East Anglia ONE North and East Anglia TWO Offshore Windfarms

Applicants' Responses to Examining Authority's Written Questions

Volume 18 – 1.18 Transportation and Traffic

Applicants: East Anglia ONE North Limited and East Anglia TWO Limited
Document Reference: ExA.WQ-1.D1.V1_18
SPR Reference: EA1N_EA2-DWF-ENV-REP-IBR-001085 Rev 01

MARLESFORD MITIGATION SCHEME (A12)
PRELIMINARY DESIGN
(SHEET 1 OF 2)

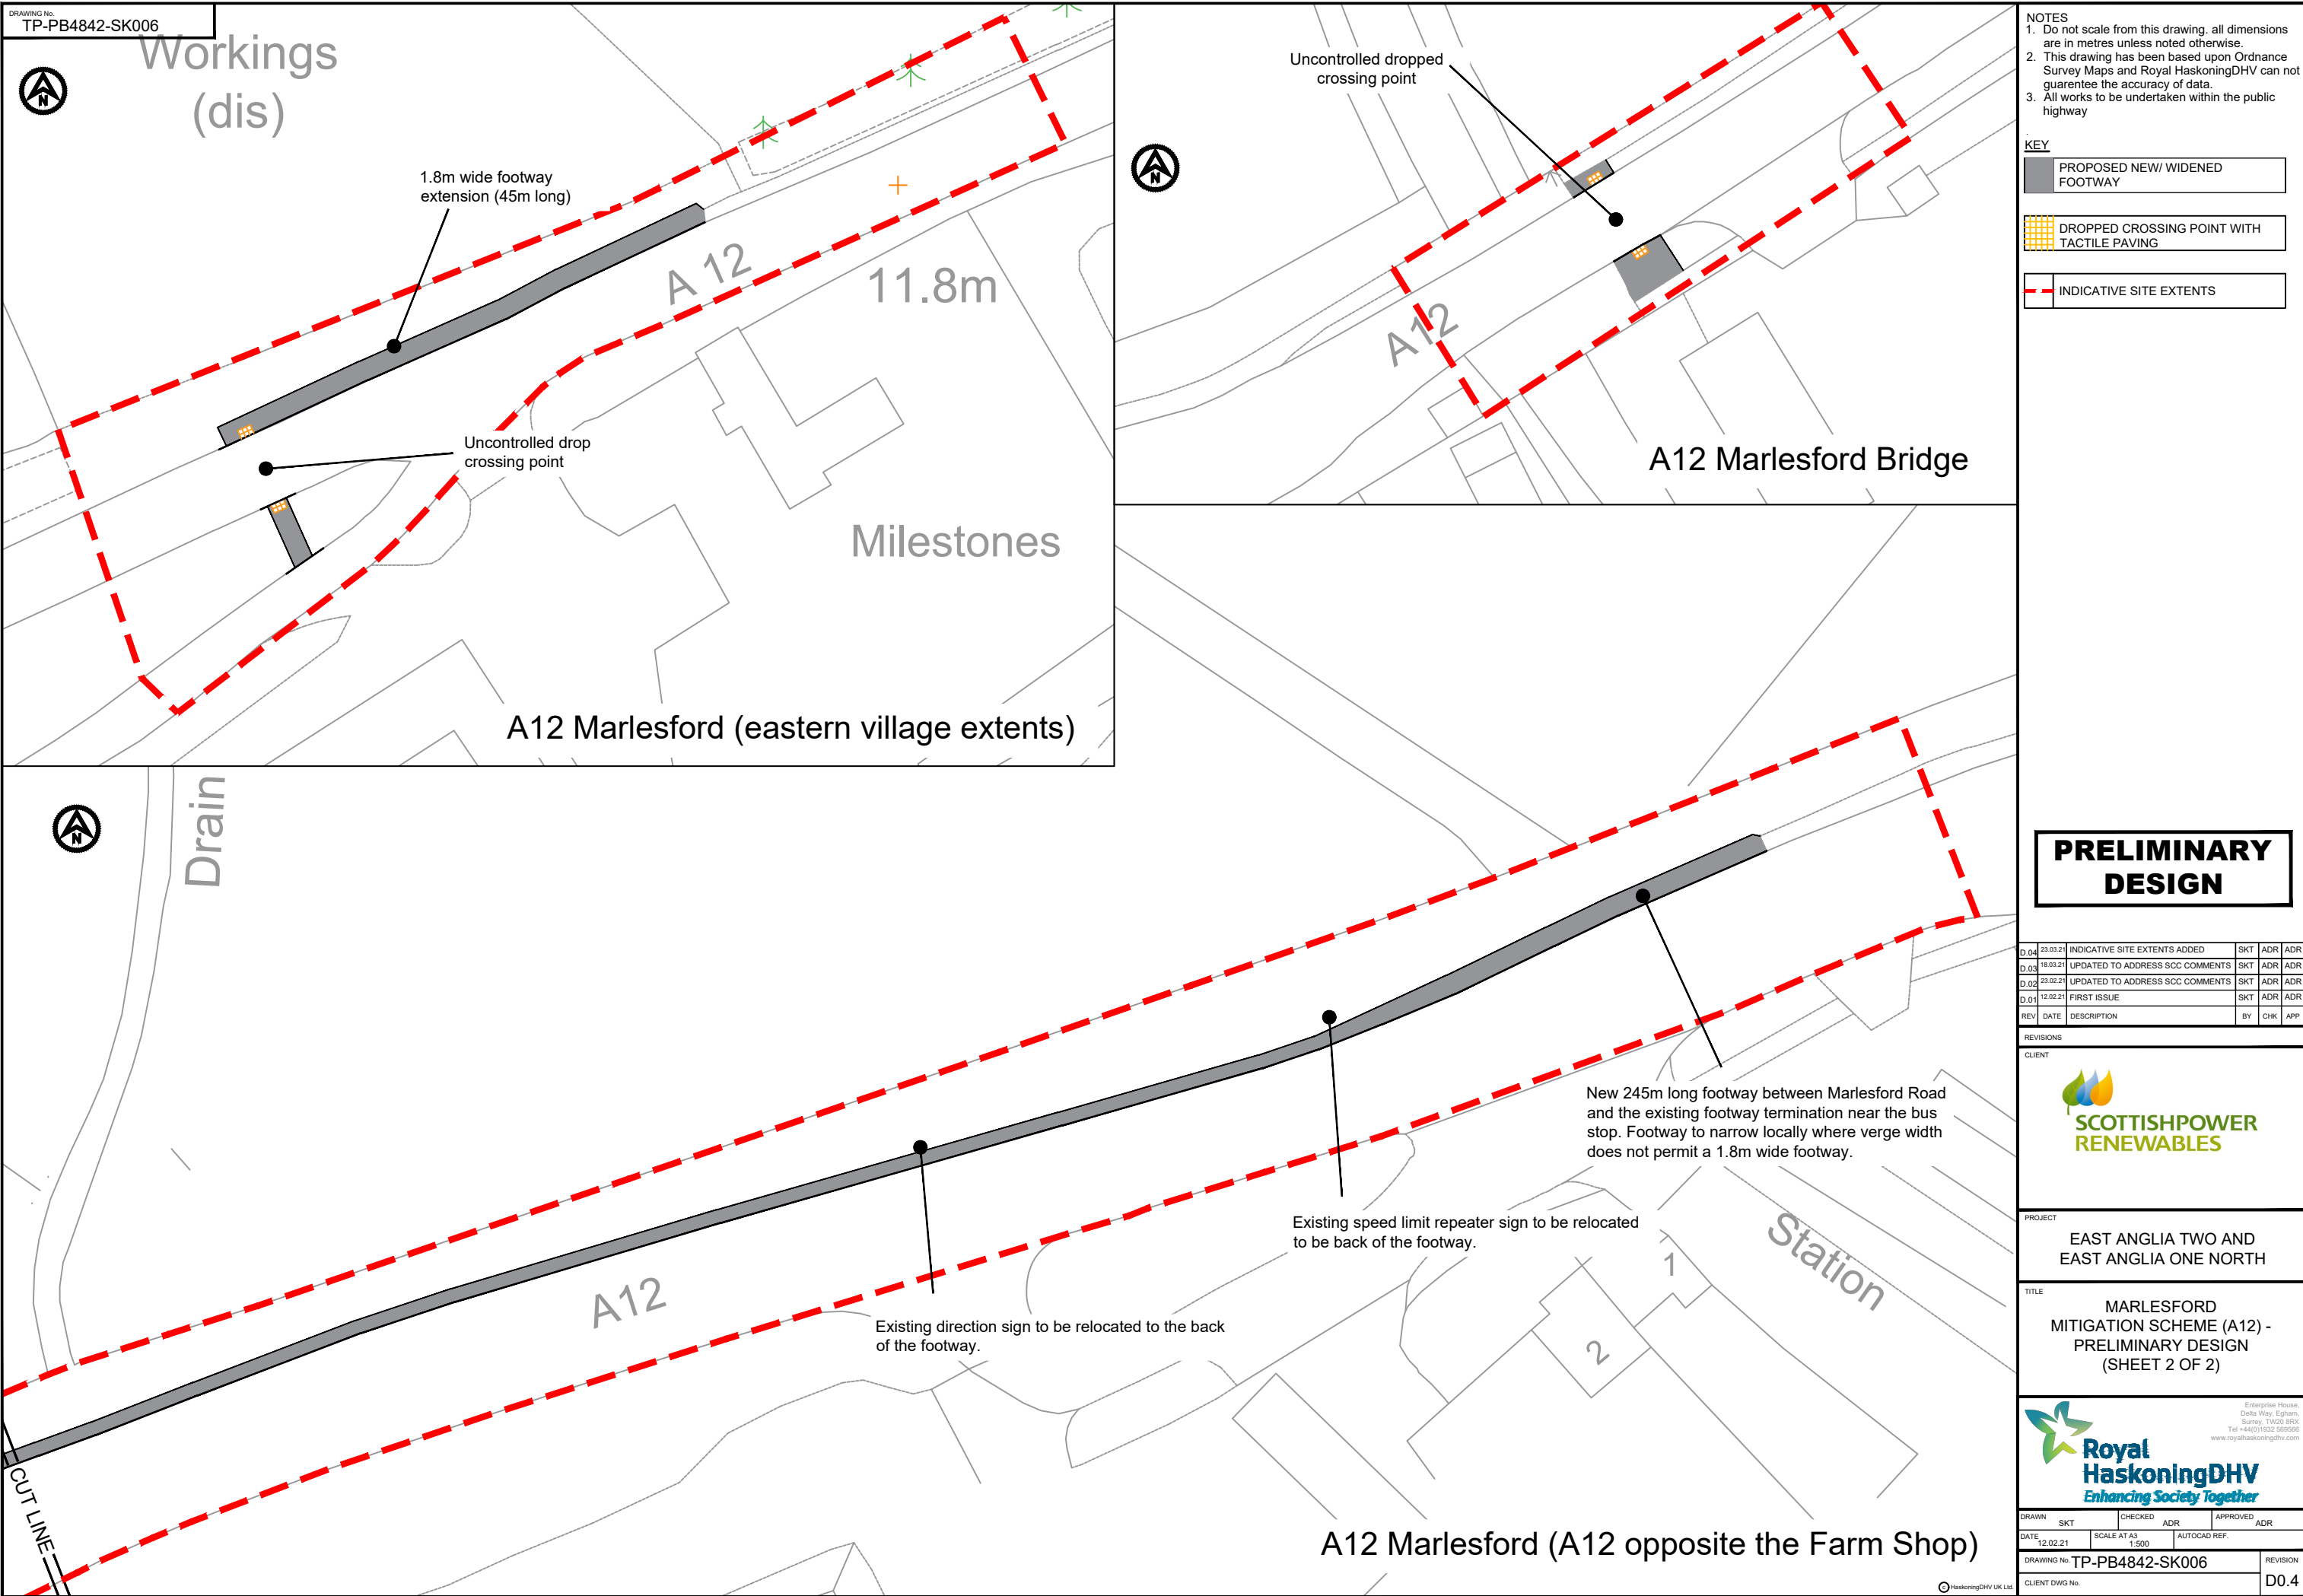
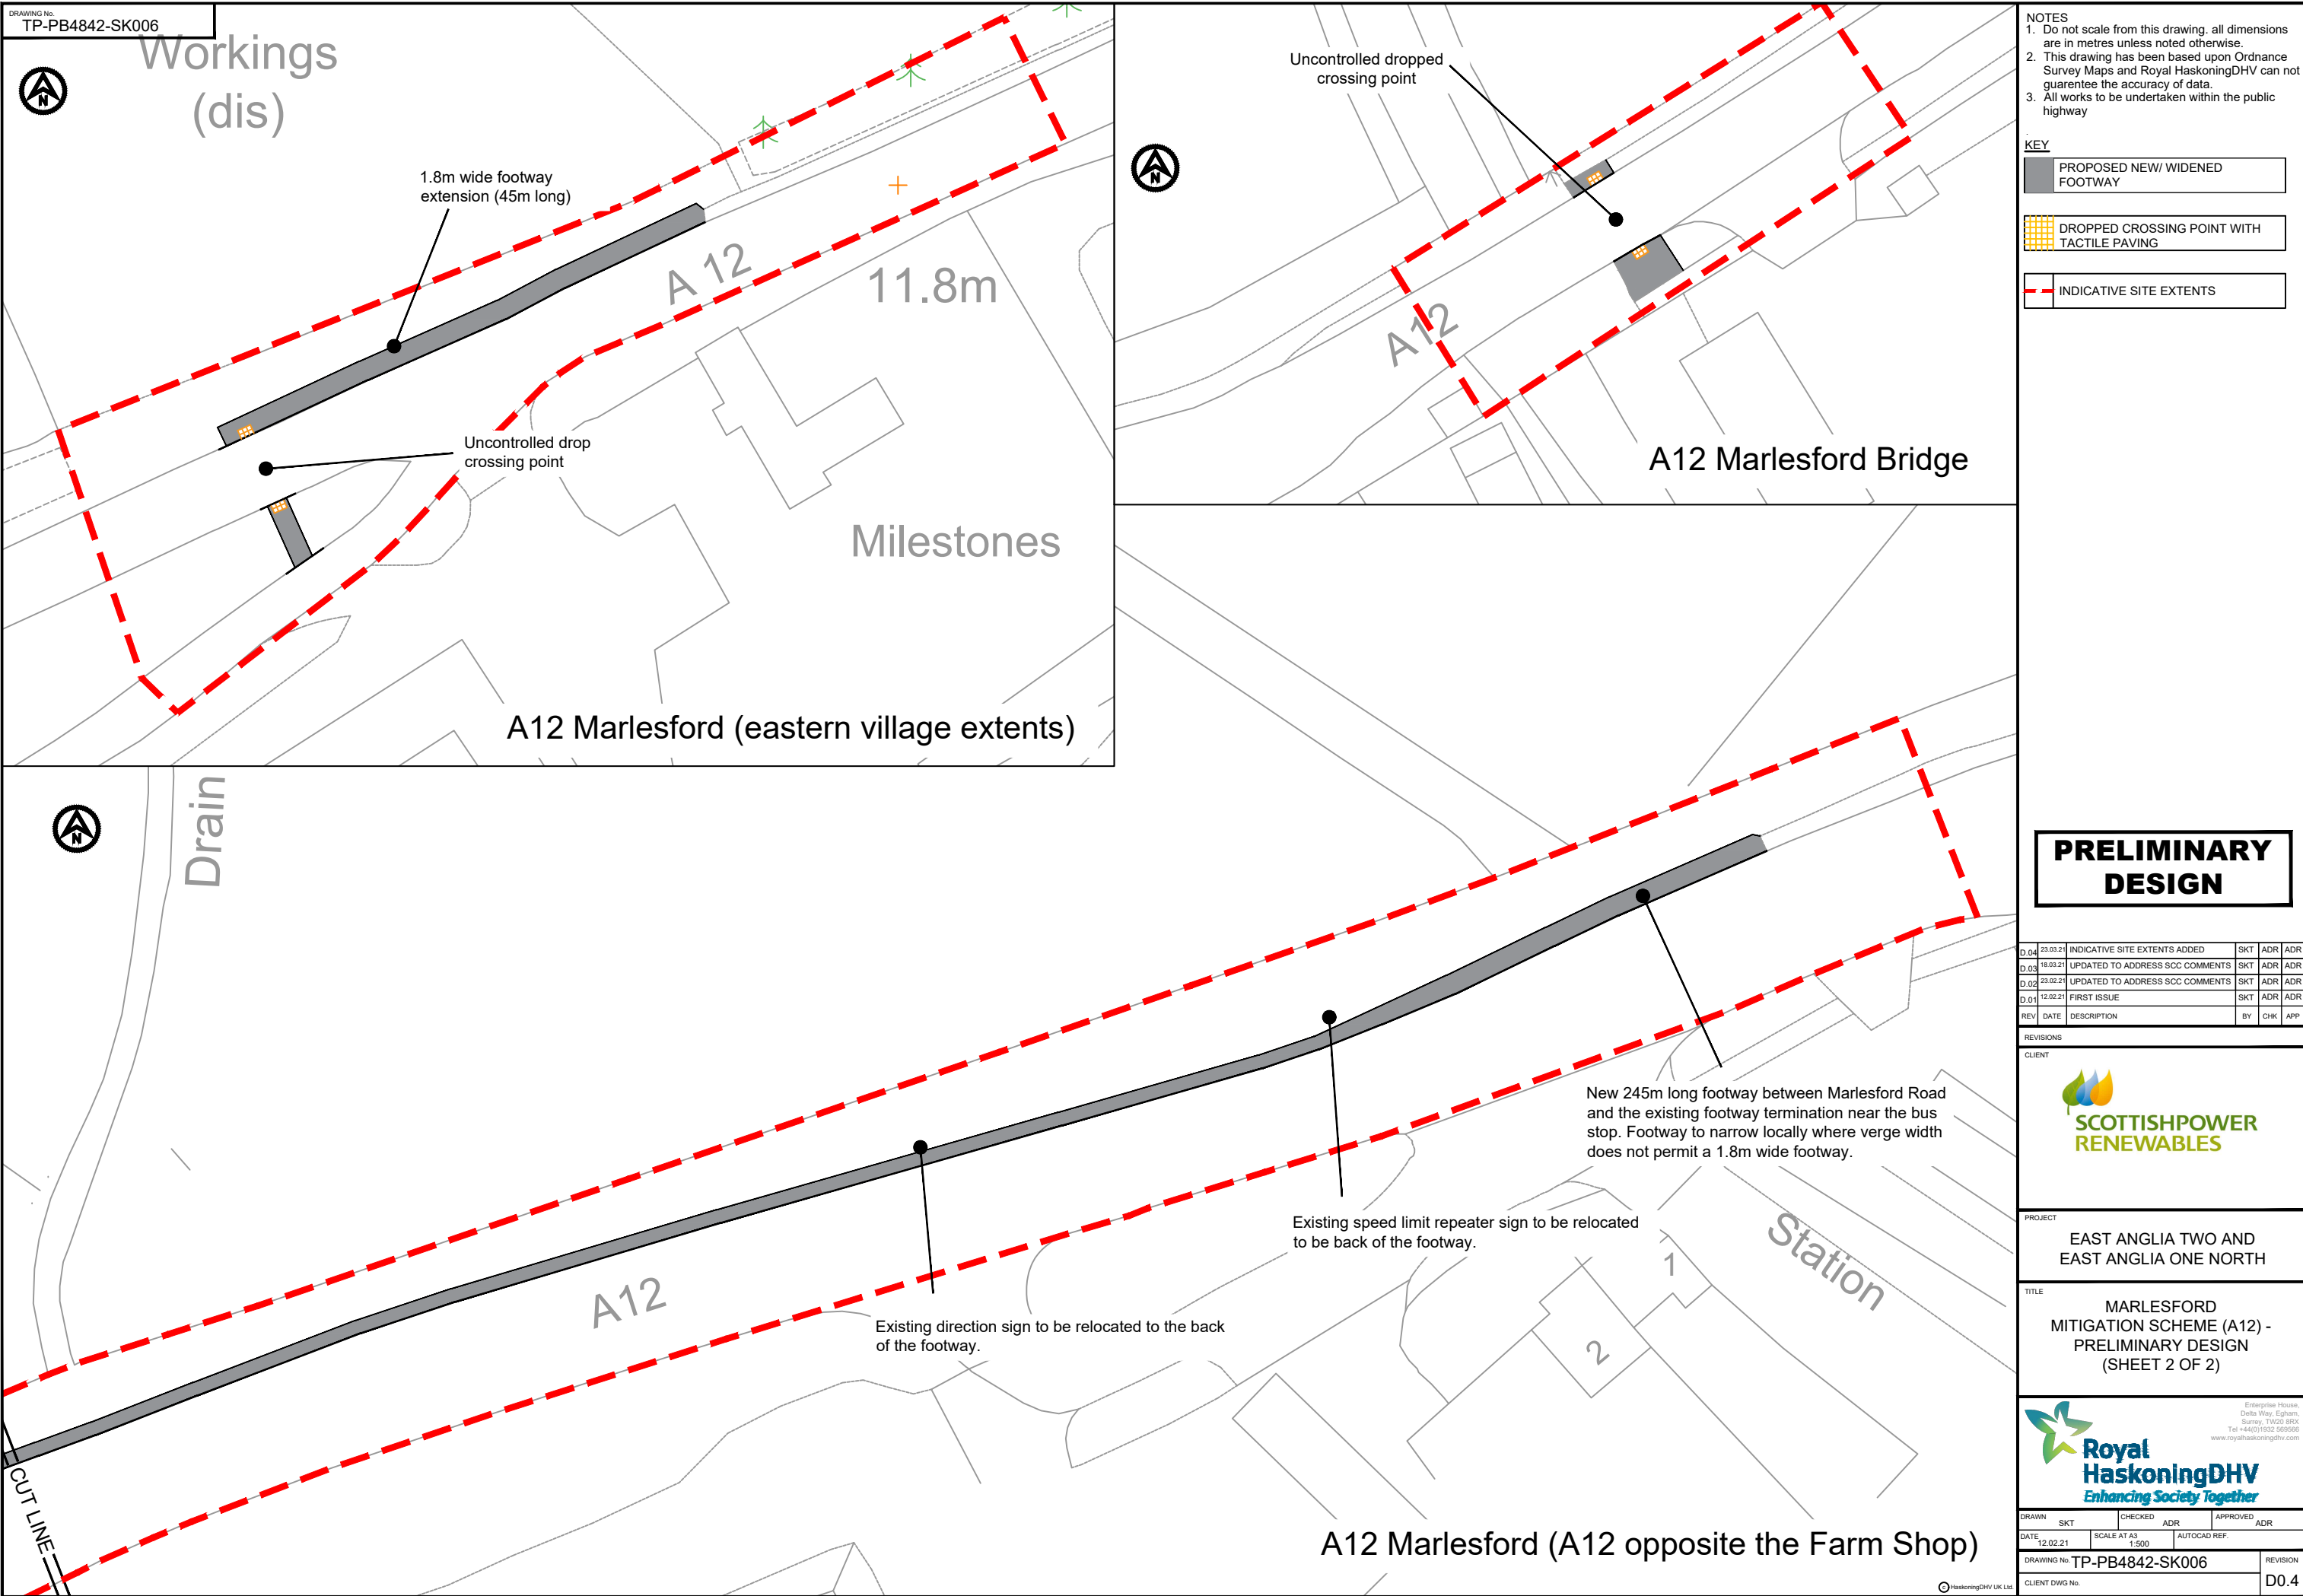
1.18.20	The Applicant	1	2	<p>Table 26.2 states that “Potential structural alternations [sic] “ are required to Marlesford Bridge on the A12 to facilitate the movement of AIL vehicles over this bridge.</p> <p>a) What structural alterations do you envisage? b) Do you yet know whether these alterations will be required? c) How will it be possible and what is the business case for these structural alterations to be temporary rather than permanent? And which access routes will be utilised by AIL?</p> <p>The scope or scale of structural alterations has not been determined at this stage due to AIL route and load variables (see response to Q1.18.19).</p> <p>If the A12 South is identified as the preferred AIL haul route, there are a broad range of interventions available ranging from temporary load bearing solutions to, at the top end of the scale, bridge alterations. Bridge alterations may be more permanent in nature. These will be determined pre-construction and the necessary technical approvals will be acquired from SCC.</p>
